From: Simon Davis
Sent: 16 August 2019 15:27
To: Planning.Responses
Subject: FW: BR/73/19/PL 3 Houses at Royal Norfolk Hotel
Attachments: BLOCK PLAN.pdf; AUG STREET SCENES 2.pdf

Drg No: **RNHB.PLAN 3**

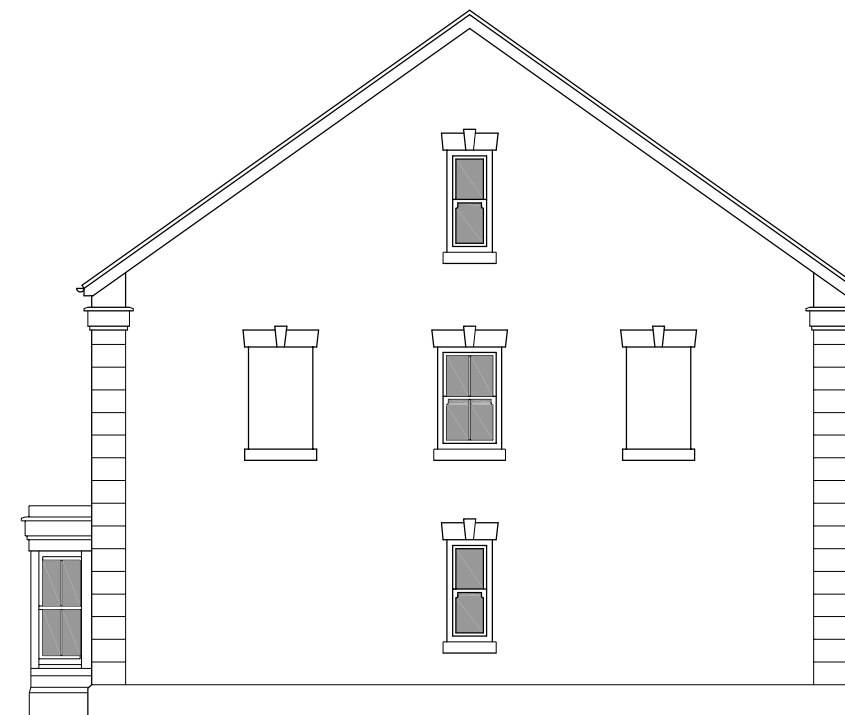
I have spoken to Martyn about the bay windows and as long as the GF bay window detailing is continued upwards, he has no objections. I also don't consider that there will be any need to reconsult as the change is trivial.

I will be happy to amend the front elevations to double height bay windows in accordance with Group Head's comments, but I would not wish to delay determination with re-consulations?

He has also commented that most/all other properties in West street have double/triple height bay windows (however, he has not asked for this to be changed).

Please find plans and elevations amended with double bay windows, together with street scene showing the houses to the north of the site on the west side of West Street.
